Submissions to EIS		
Issue #	Issue	Draft response
DP&E 1	The justification for contravention of the height development standard in the Warringah Local Environmental Plan 2011 has not been satisfactorily argued. Further assessment is required detailing how both the community health centre building and car park structure impacts on adjoining sensitive receivers when considering the objectives of Clause 4.3 of Warringah LEP 2011	Listed adjacent are the objectives of clause 4.3 height of buildings. As noted in the EIS, the height and design of the building is a function of the services provided. In terms of the increased height, the proposal is considered to meet the objectives of the control for height of buildings as follows: (a) The proposed building is comparable to the height and scale of many of the recent new developments along Pittwater Road and Warringah Mall opposite. The site is within an area undergoing change in the urban fabric and the proposed development will provide a land mark building for the delivery of primary health services to the Warringah Community. It is considered that the proposal is compatible with the newer developments in the surrounding area and will be

Drawing No
CHC-BV-AR-SSD-303

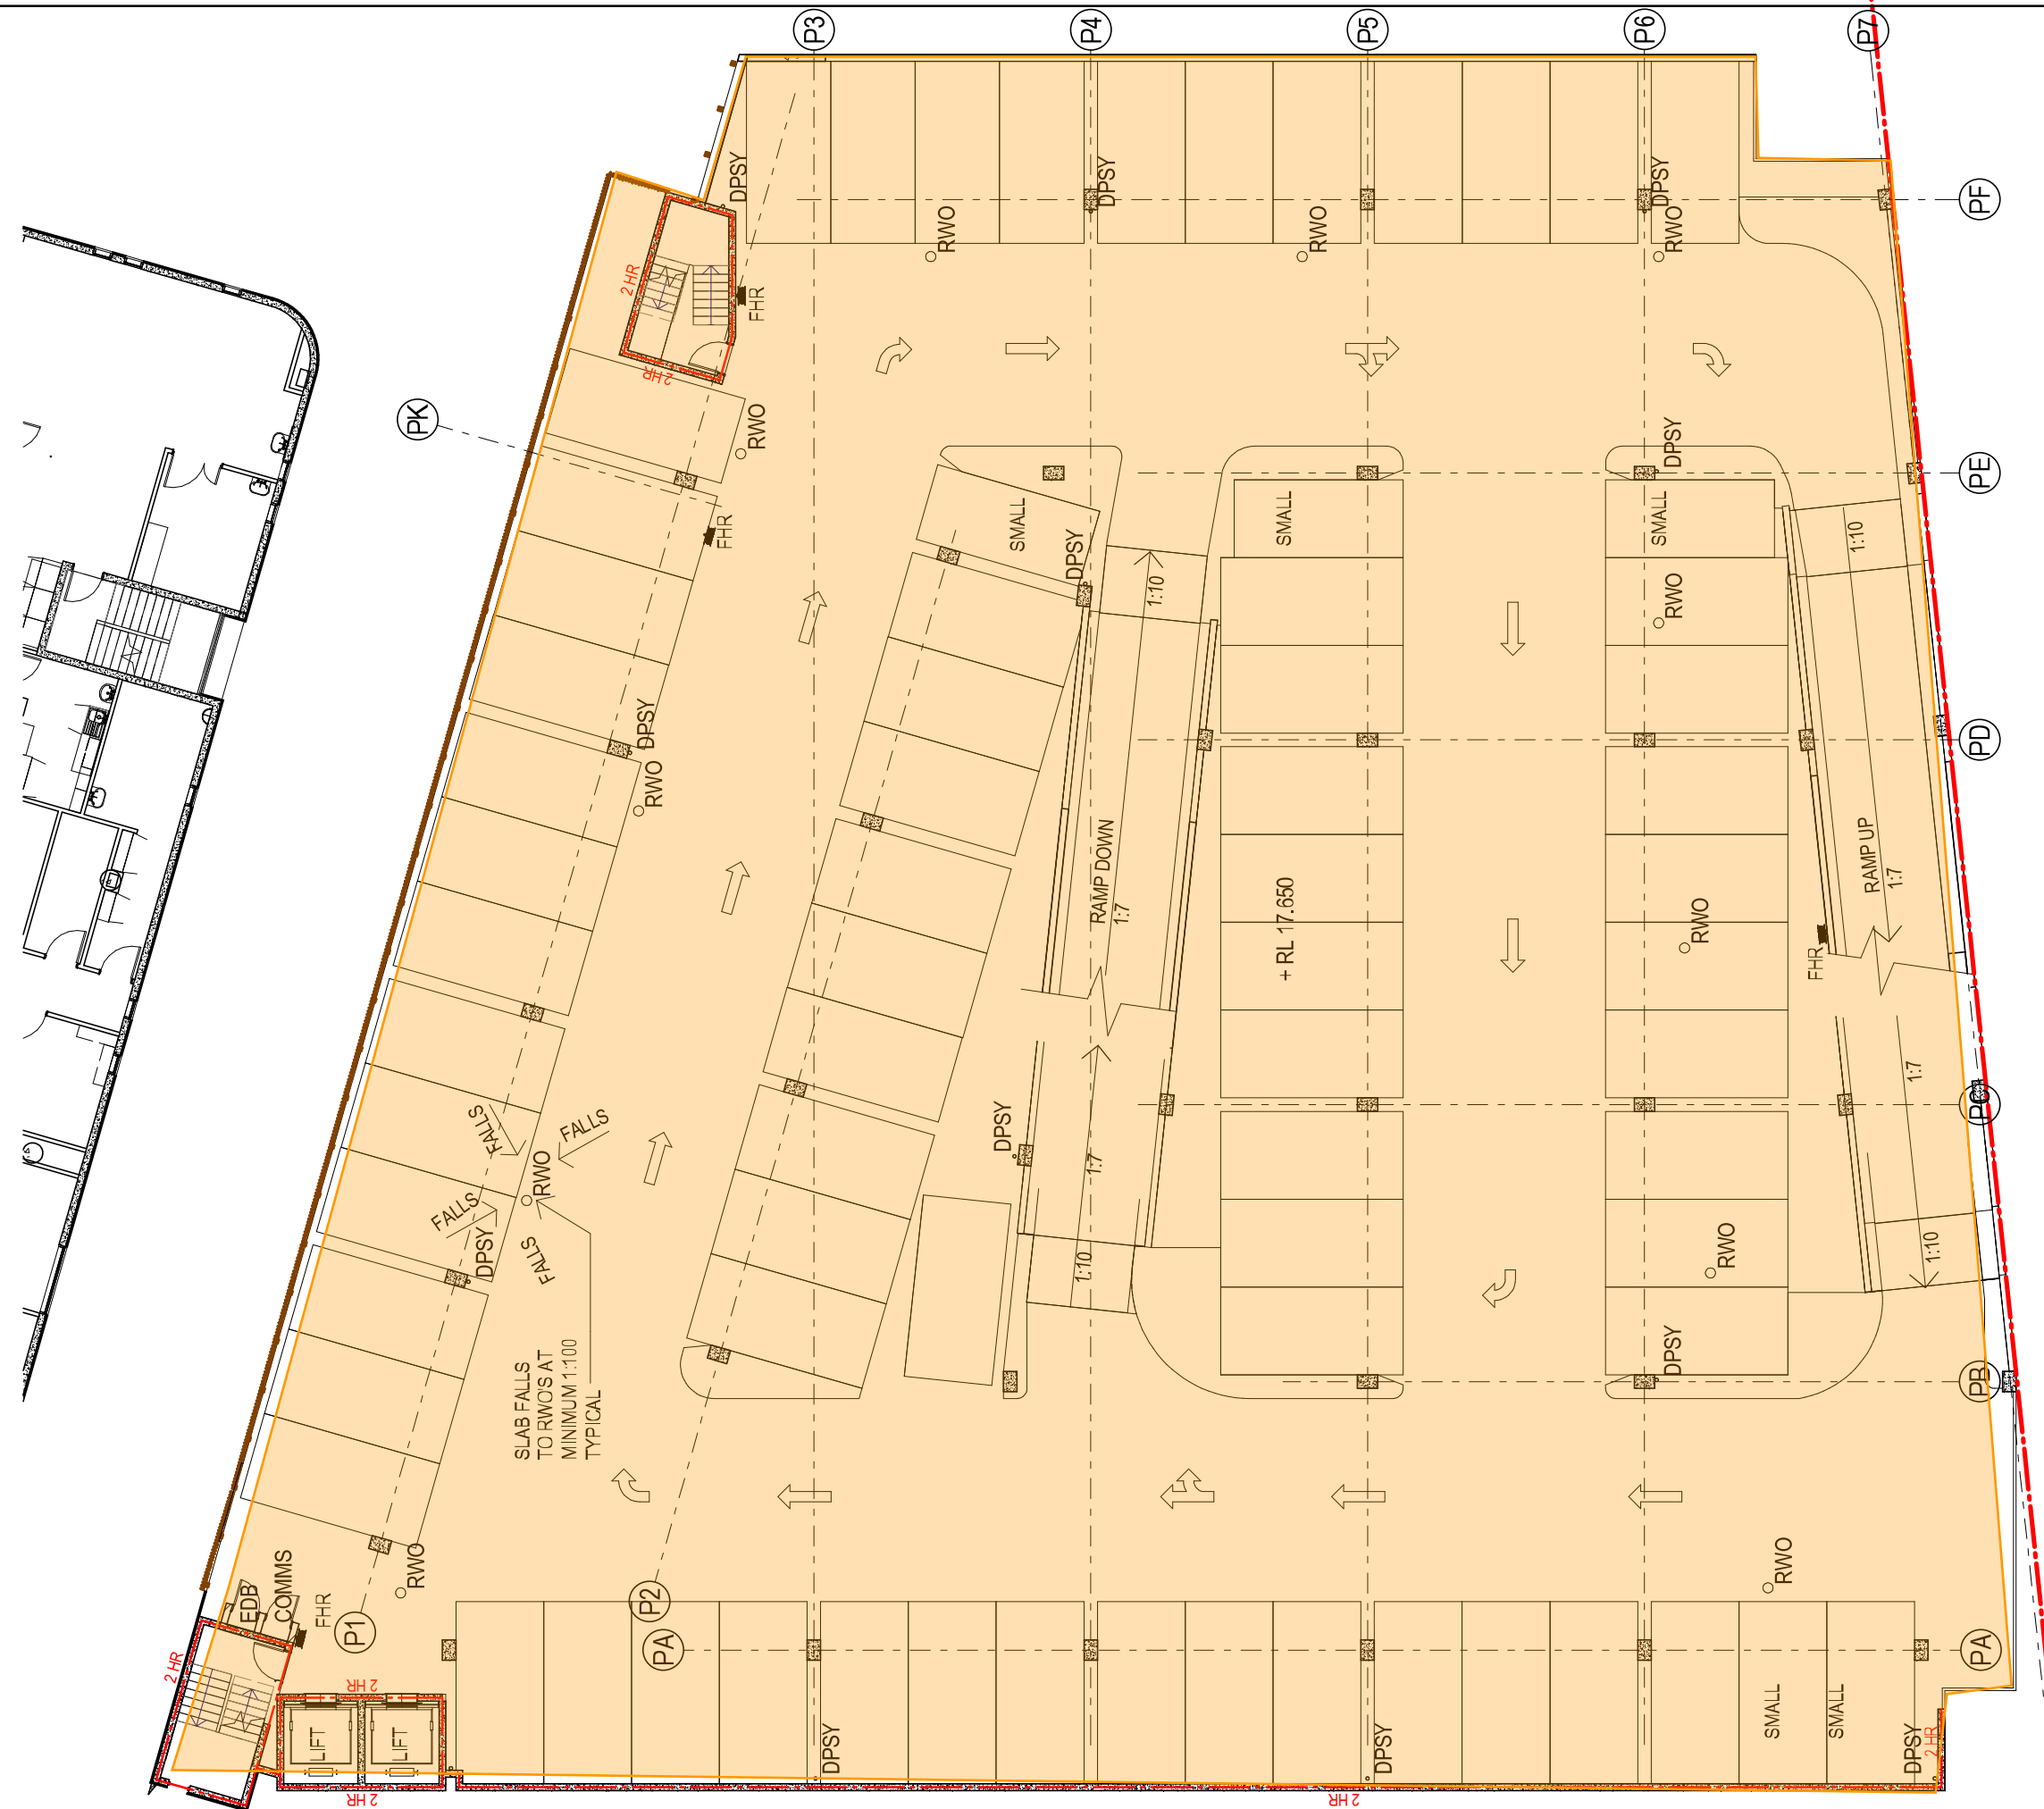
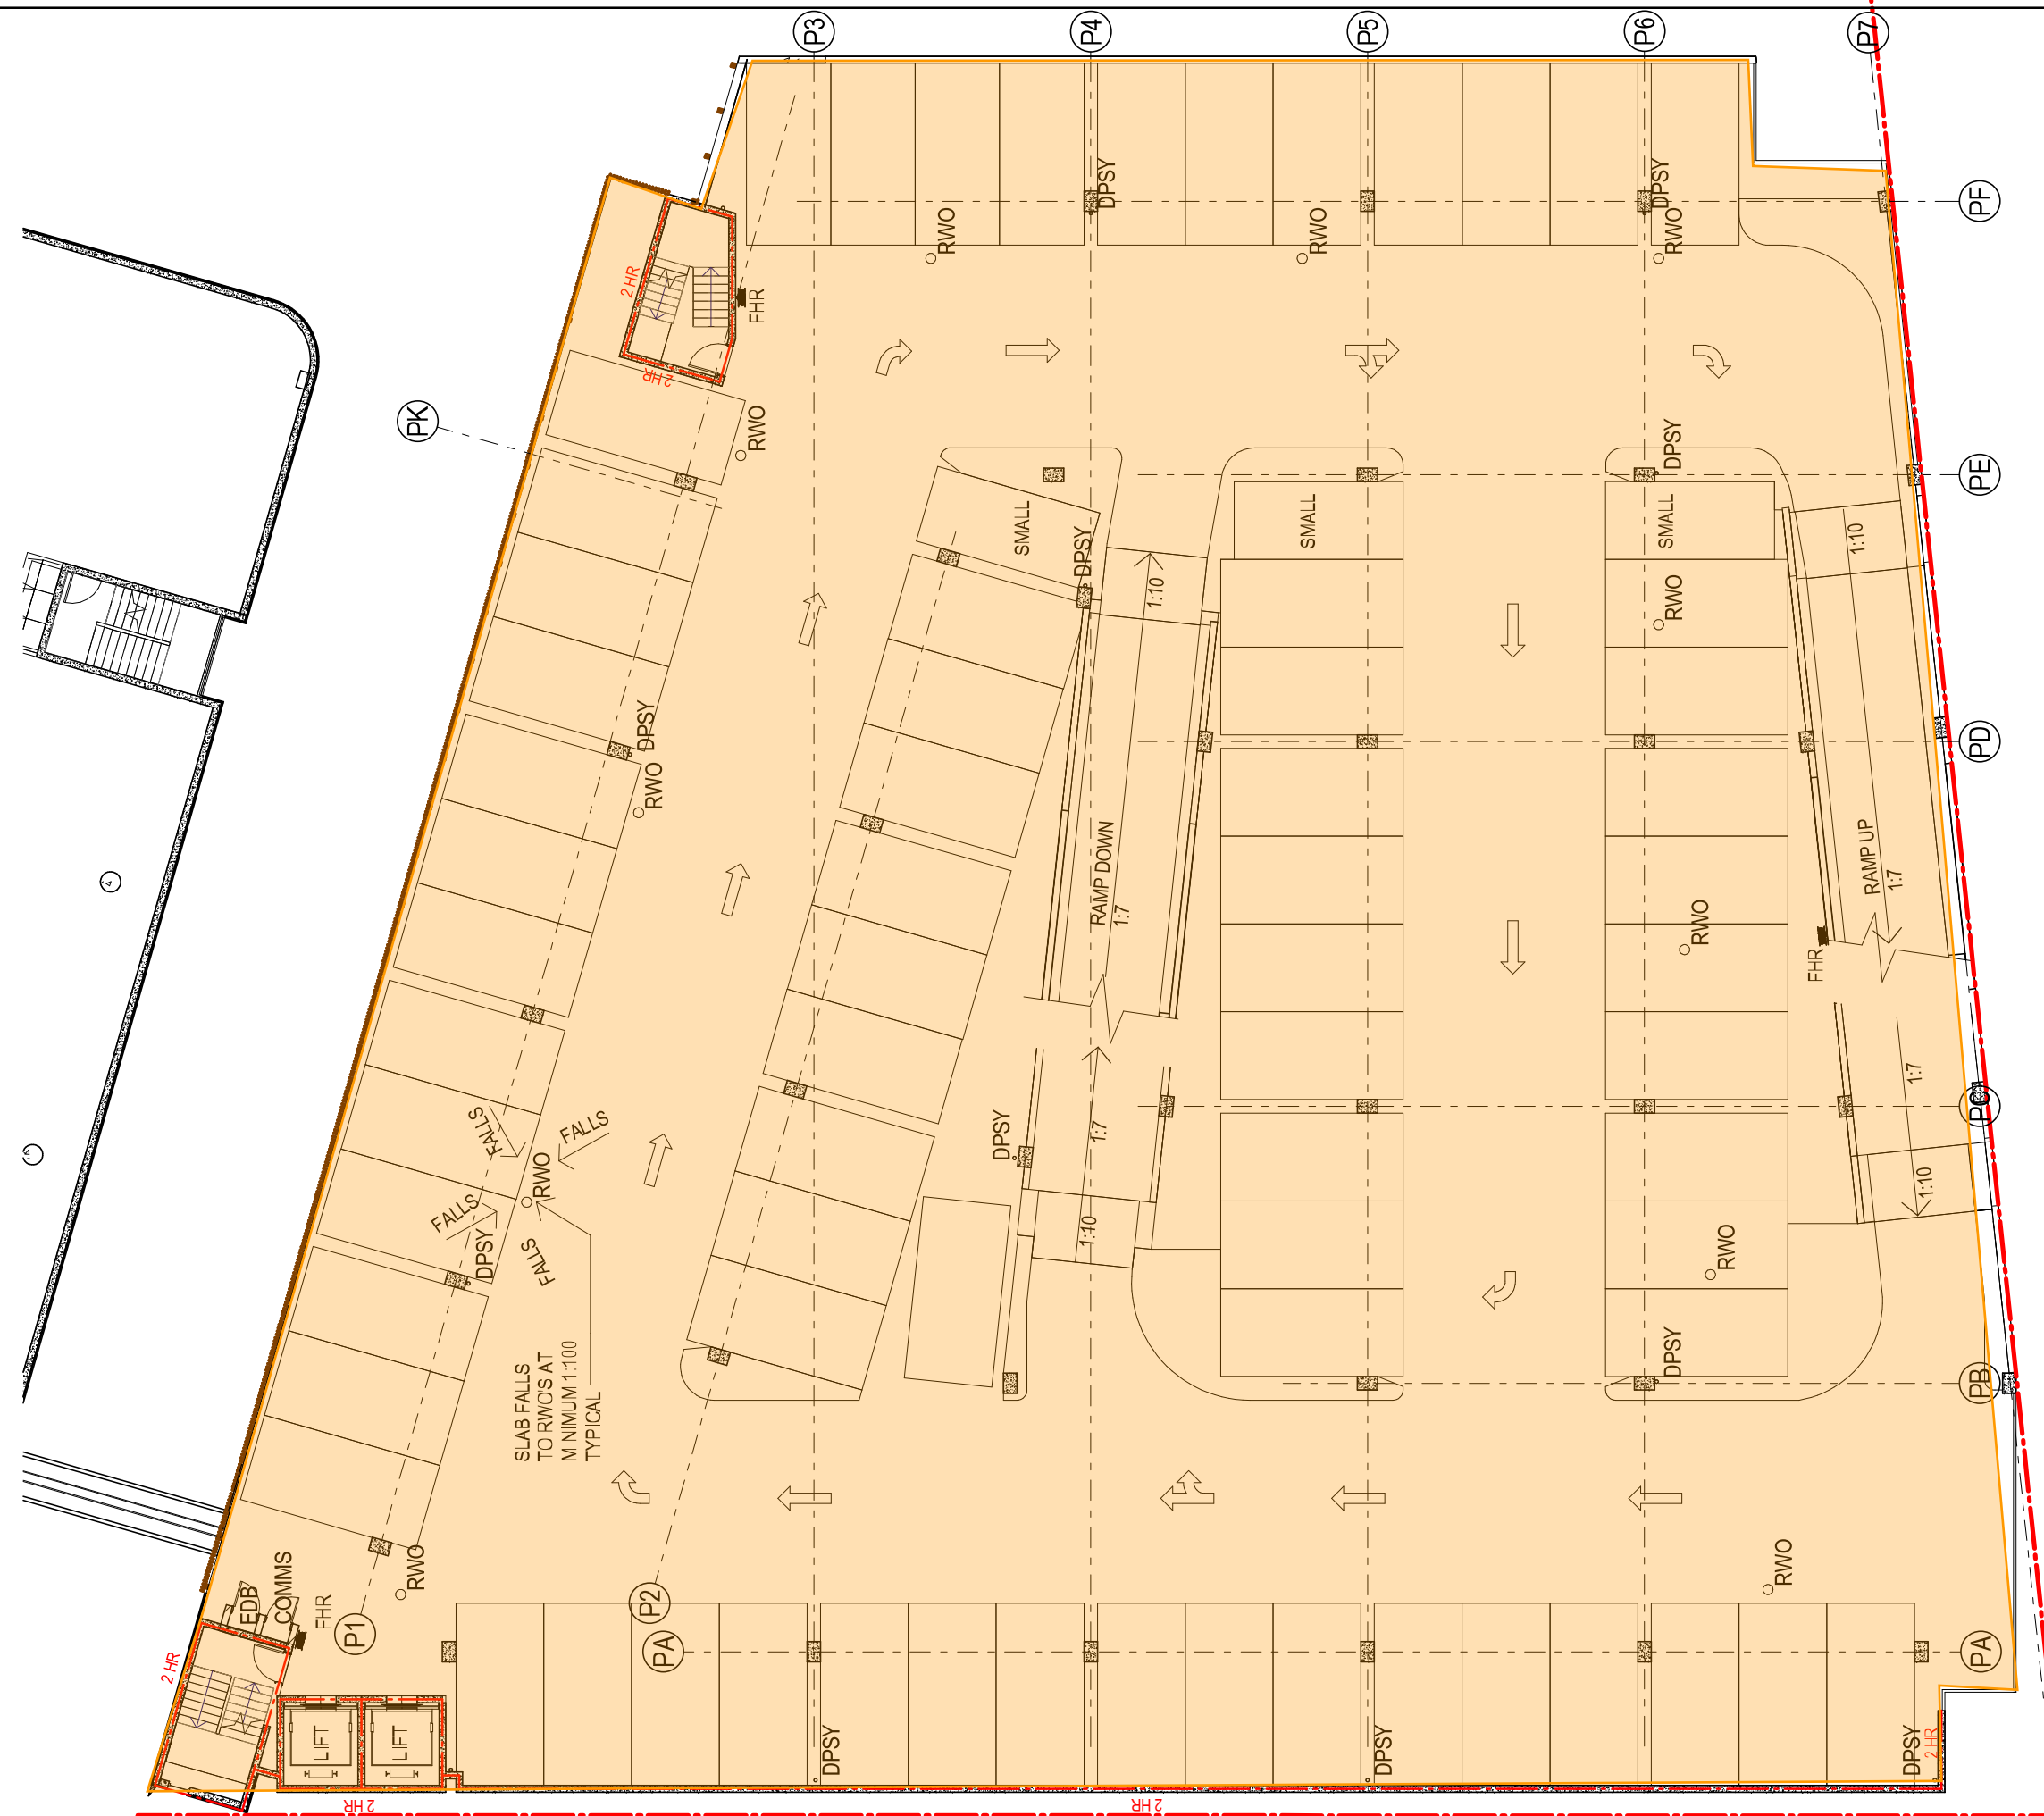
DP&E 3	Details of the car parking to be provided including total floor area, height level and demonstrate access to and from the community health centre for staff, clients and commuters, including after business hour access	<p>Car Park Top level is at RL29.5 with the lift core at RL 33.8</p> <p>Access Staff - Staff can access the Community Health Centre via the link bridge at level 5 of the car park or by taking the lift to the ground floor and utilising the pedestrian crossing provided. Staff will have access to the building out of hours with a swipe card. This access will only be given if the staff member requires out of hours access. Clients - Client Parking is all on Level 1 of the car park with level access available to the Community Health Centre. Clients will access the building out of ours by an intercom system connect to out of hours services occurring on site. Commuters would not generally require access to the Community Health Centre. Commuters will park on levels 2-5 of the car park and take the lift to the ground floor before utilising the pedestrian crossing and then the breezeway to the bus interchange. The Breezeway is open 24 hours a day.</p> <p>The Car Park Floor Areas are as follows (m2): Level 1 2210 Level 2 2283 Level 3 2327 Level 4 2327 Level 5 2327 Level 6 2327 Level 7 2327 Total 16128 m2</p>

1 ELEVATION - MAIN BUILDING WEST A
1 : 200

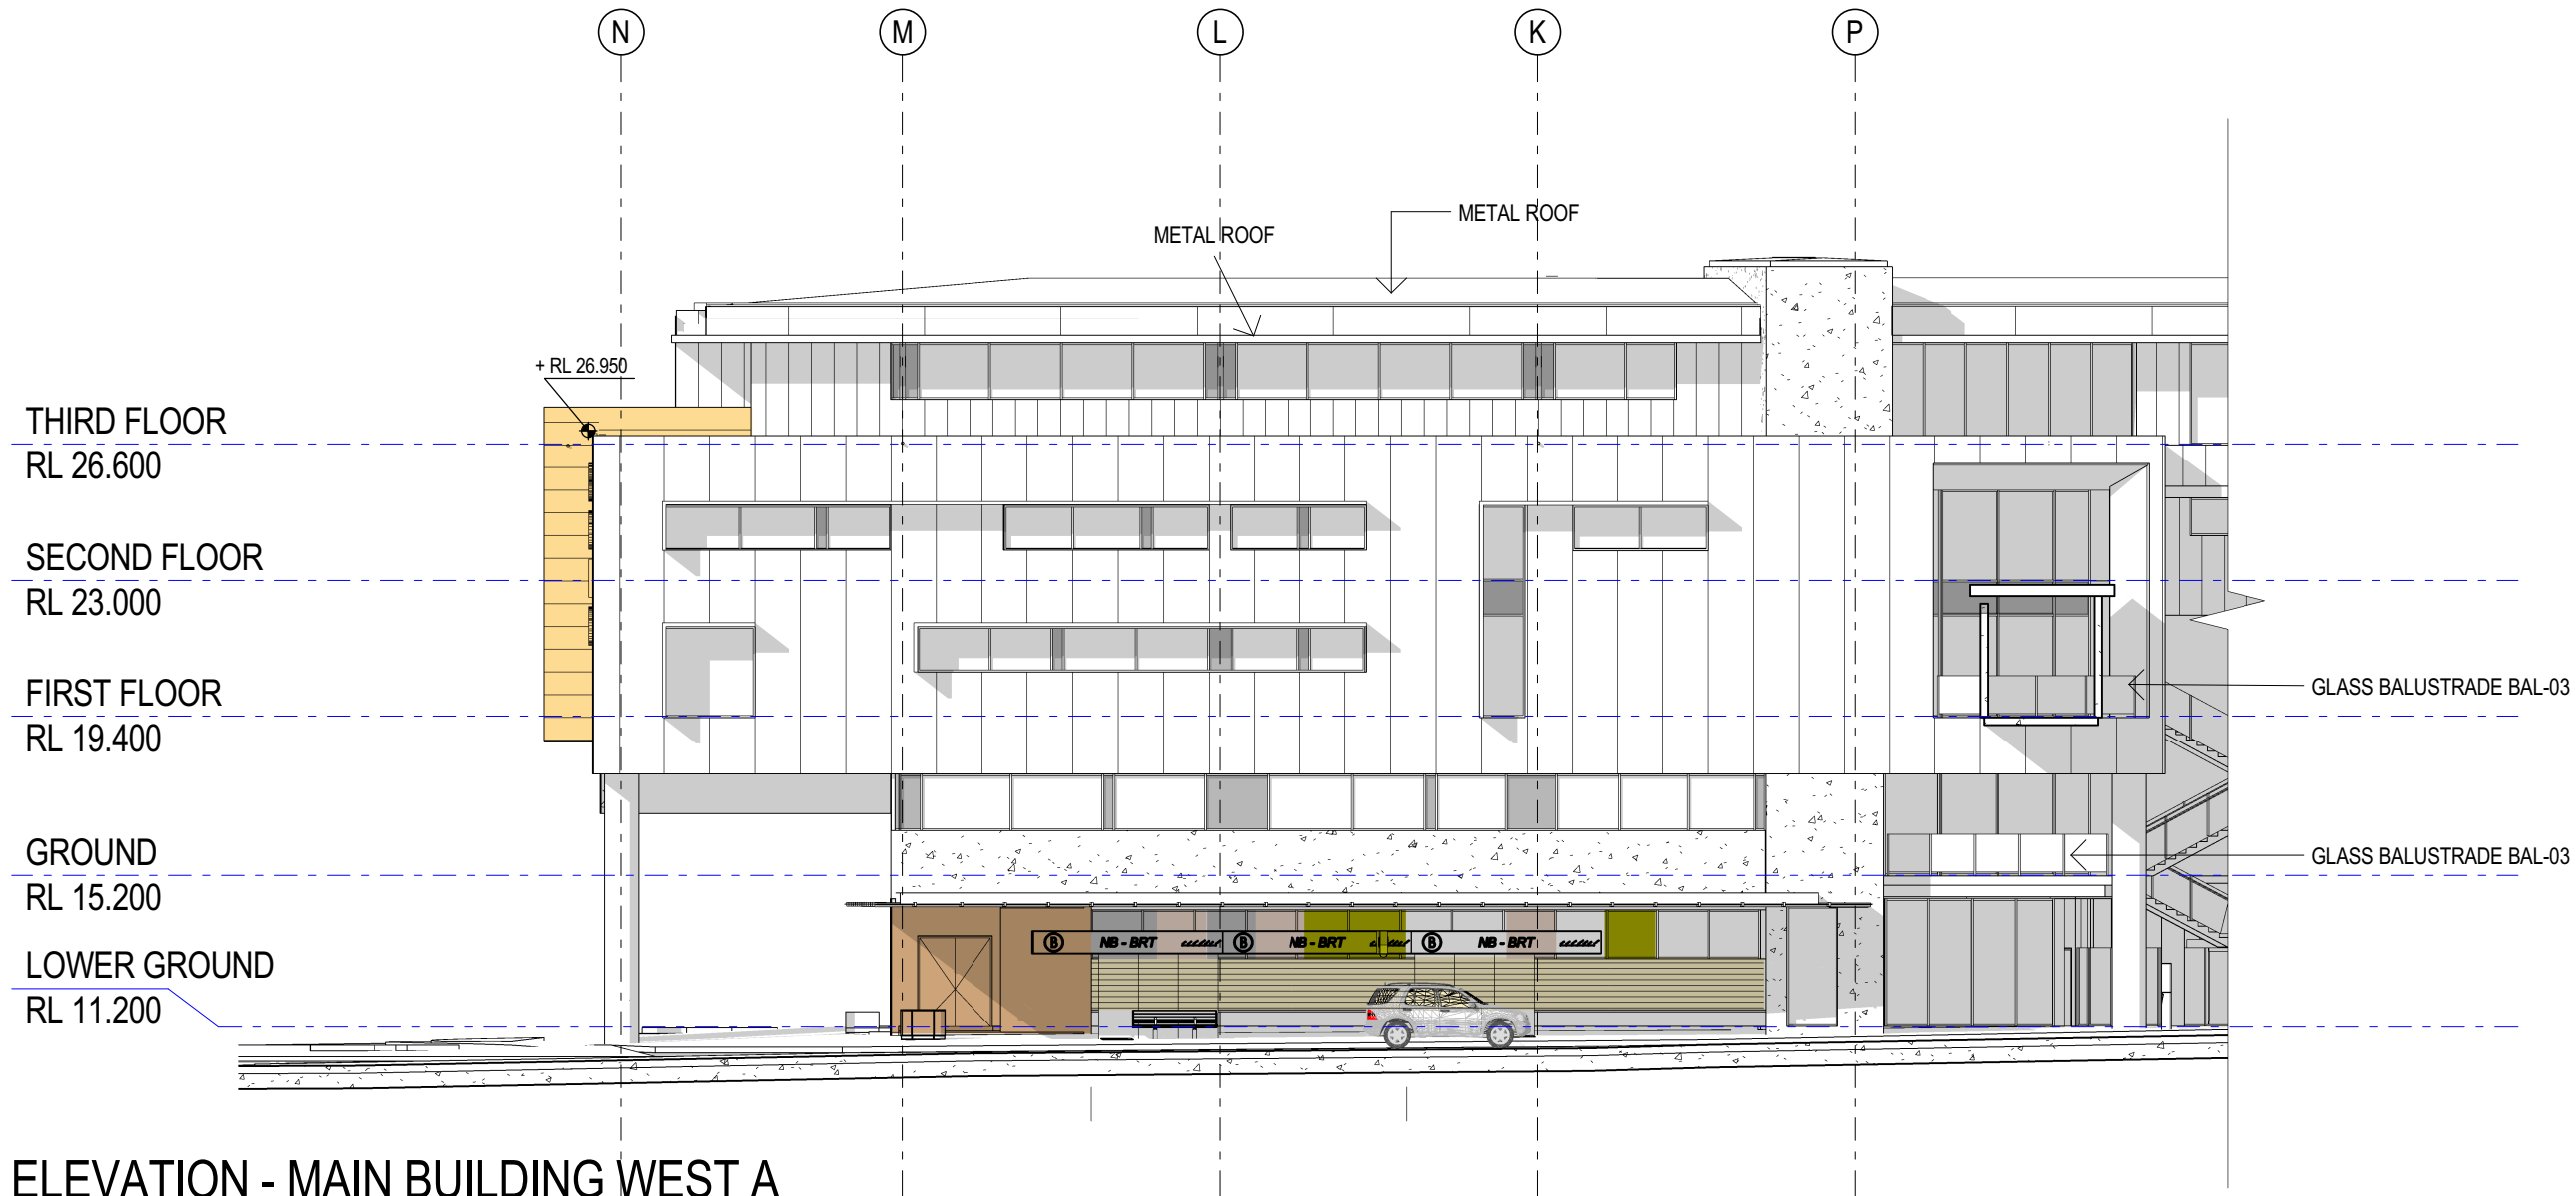
Submissions to EIS		
Issue #	Issue	Draft response
Council -3	While both ends of the building facing Pittwater Road are important, the priority is the south west corner, given that it acts as a 'Gateway' to Brookvale and will be very visible, sitting on the corner of this busy intersection. Council would like to see the south-west corner of the building softened with more rounded or curved elements introduced and through the use of innovative architecture and materials/colour/texture.	We recognise and understand the importance of the southern corner of the facility and its impact on the streetscape. The changes to the facade and its articulation have improved on the original design and HI is of the view that the design is appropriate for the location. Curved elements are problematic for the internal uses of the building and will result in loss of vital floor space critical to the functioning of the building.
